PINE VIEW ESTATES FILING NO. 1 PRELIMINARY PLAN

SECTION 13, TWP 11, RANGE 64 WEST OF 6TH PRINCIPLE MERIDIAN
EL PASO COUNTY, COLORADO

PCD FILE NO: XX-XX-XXX
SP-20-004

**PINE VIEW ESTATES  
FILING NO. 1  
PRELIMINARY PLAN**

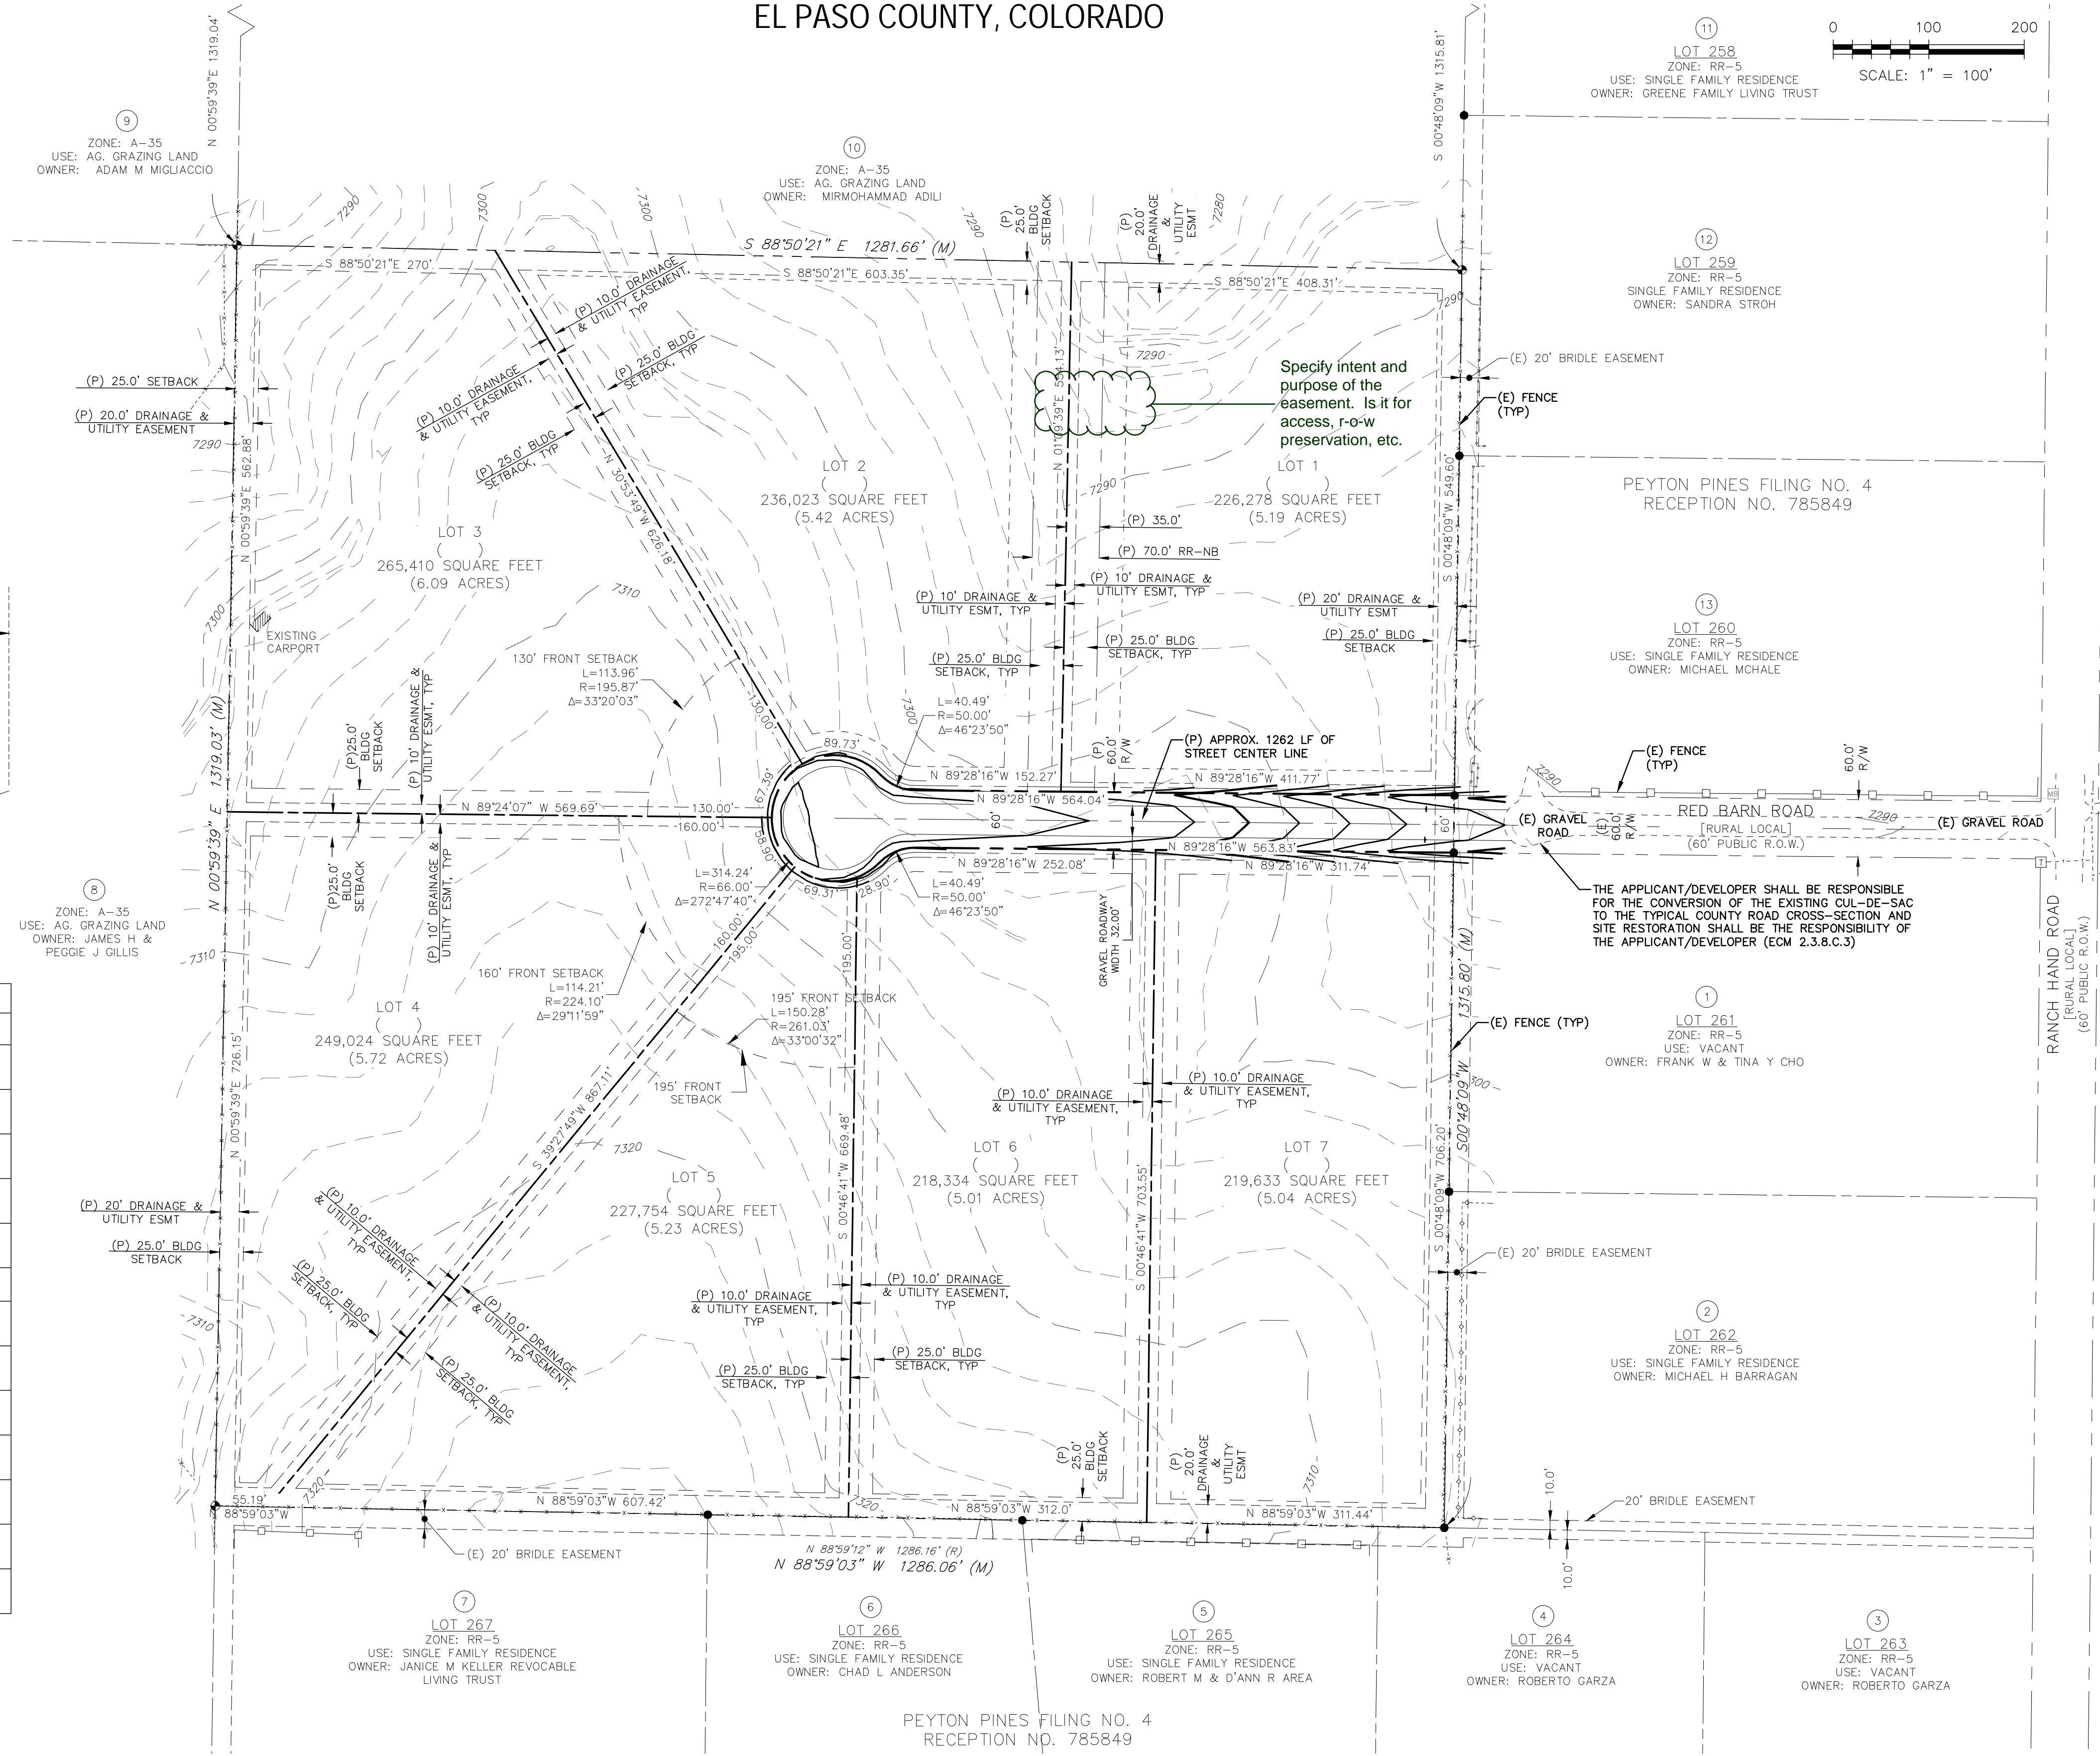
RR-5 Zoning district requires that each lot have a minimum width (measured at front setback line) of 200 feet. Please adjust the setback lines for Lots 3, 4, and 5 to comply with this requirement. It will result in those lots have a much larger front setback than 25 feet to get to the point where the lots measure 200 feet wide.

Typ. - Are these easement lines? If so, label and dimension

Please provide a preliminary grading plan.

It doesn't appear that proposed grading contours are shown. Show grading on plan.

As indicated in the staff report for the rezone (P192) future right of way for connections to the west and north shall be provided. It appears that it has been provided but it has not been labeled on the plan. Please label these as easements for future ROW dedication at no cost to the County. Staff will discuss with the County attorney to ensure that the easement is the best method for these future connections.

Please identify what this line type is.

Please identify on the plan that the applicant/developer shall be responsible for the conversion of the existing cul-de-sac to the typical County road cross-section and site restoration shall be the responsibility of the applicant/developer (ECM 2.3.8.C.3)

Does this area include the required utility easement? If so, why is a duplicate easement line shown here? If it can be included in the 70' easement provided?

Side setbacks only need to be 25' wide. Why are they so much wider here? If this is proposed to be an access easement for the lot to the west, please indicate as such.

Provide the curve data for the cul-de-sac (radius, Δ)

Please identify the bearing; typical throughout the plan.

Identify what the interior black line is at the proposed roadway.

This soil type linetype is not shown in Legend. Either freeze it on GEC Plans) or add linetype to Legend.

TYPICAL SECTION - RURAL LOCAL
SCALE: N.T.S.

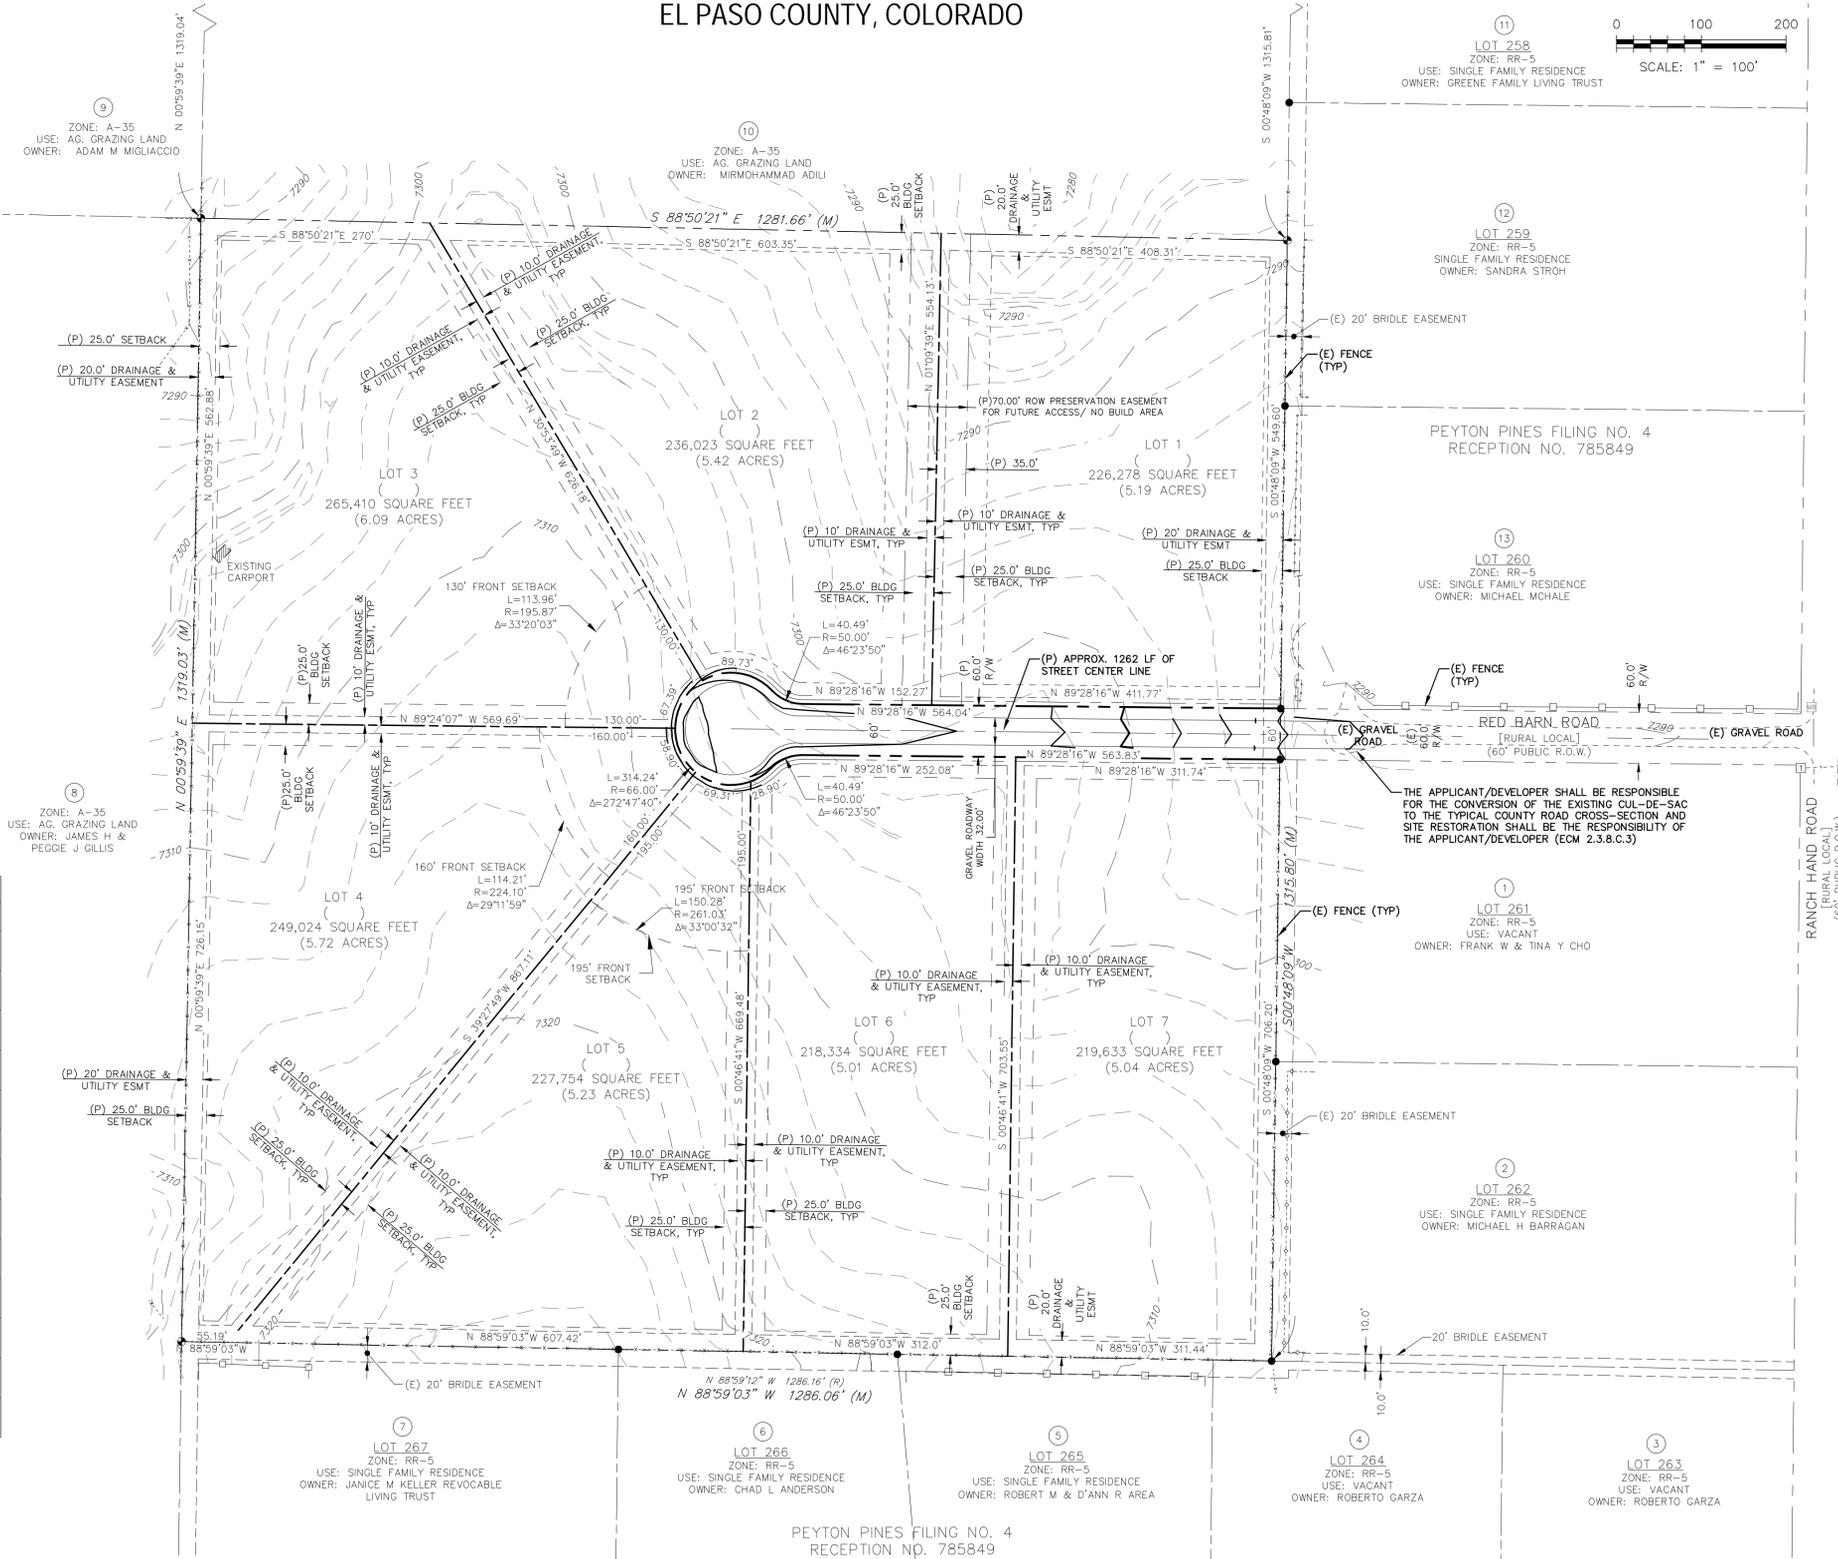
per previous notes it appears that the proposed roadway was intended to be a gravel roadway and would be allowed per ECM 2.2.7. Please revise the section detail so that the roadway is per the County gravel roadway section detail SD 2-10.
